September 21, 2023

Re: Caterpillar Clubhouse Daycare
803 2nd St. SW
30-Day Temporary Certificate of Occupancy
Transportation Development Final Inspection
Architect's Stamp dated 04-11-22 (K14-D227)
Certification dated 09-06-23

A1 TRAFFIC CIRCULATION LAYOUT

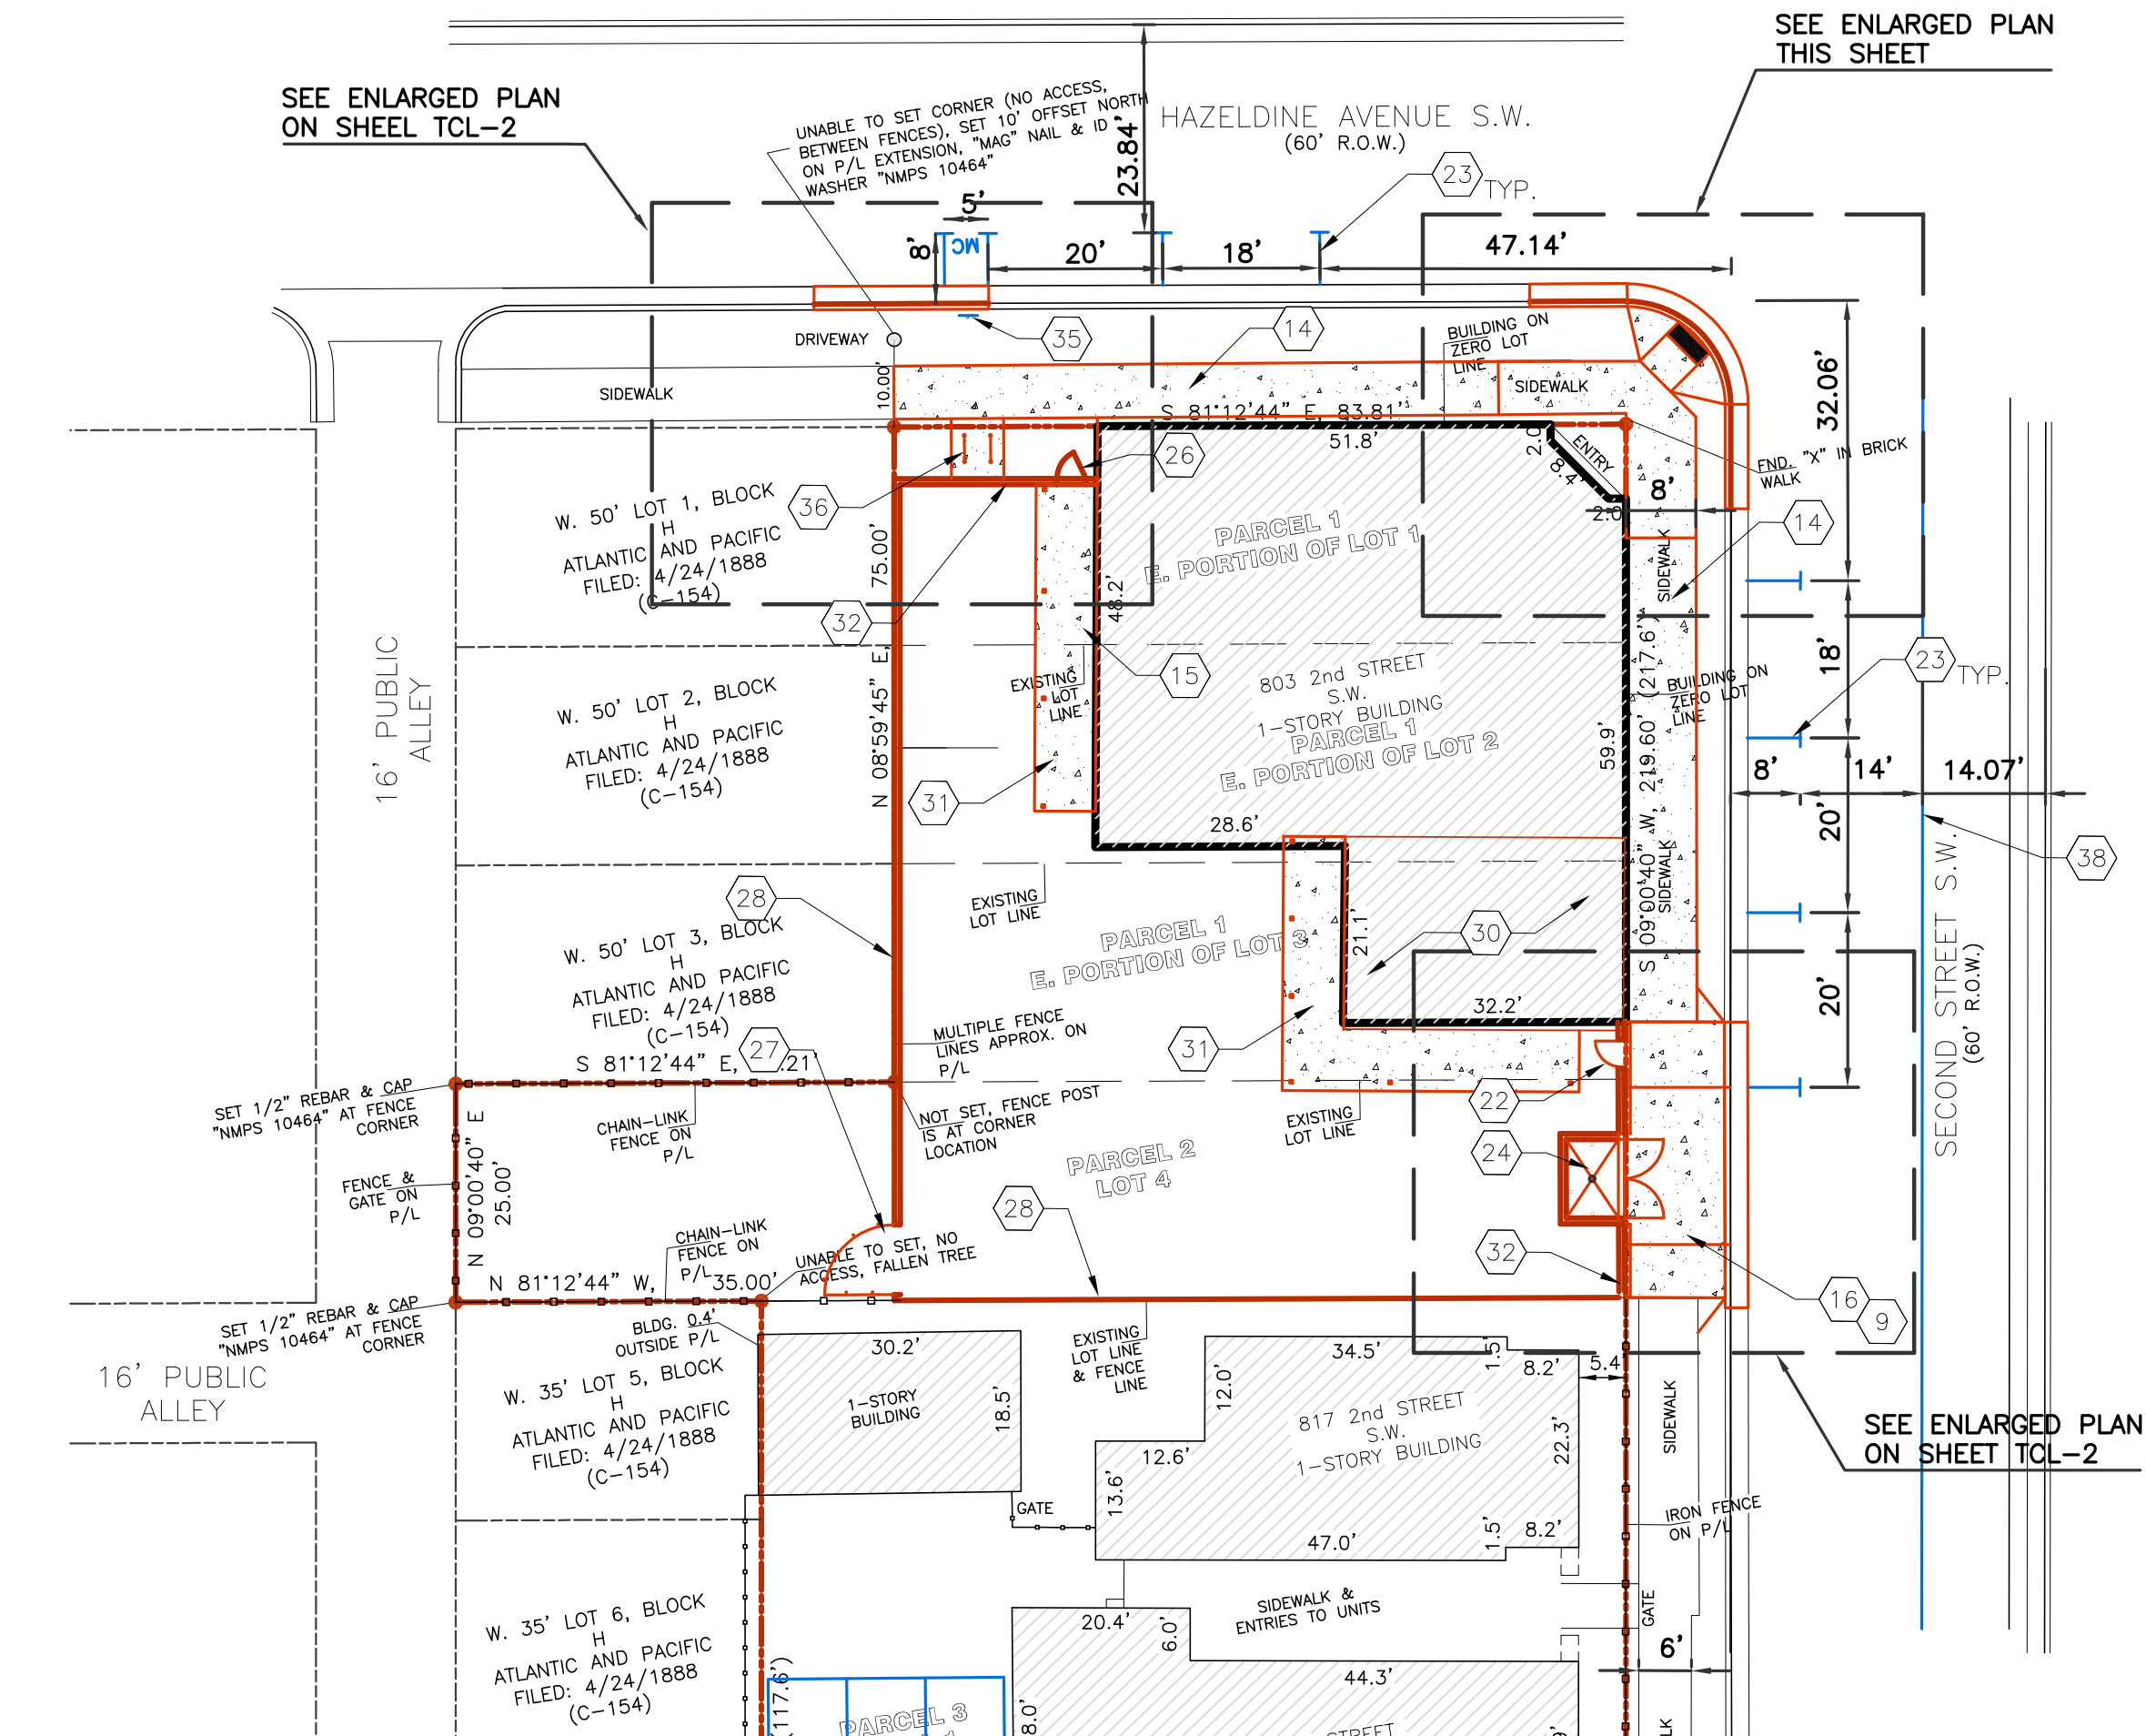
- Per approved TCL letter, please provide the Shared Parking agreement.
- Please finish the construction of the walkway path, the Personnel Gate must be installed.
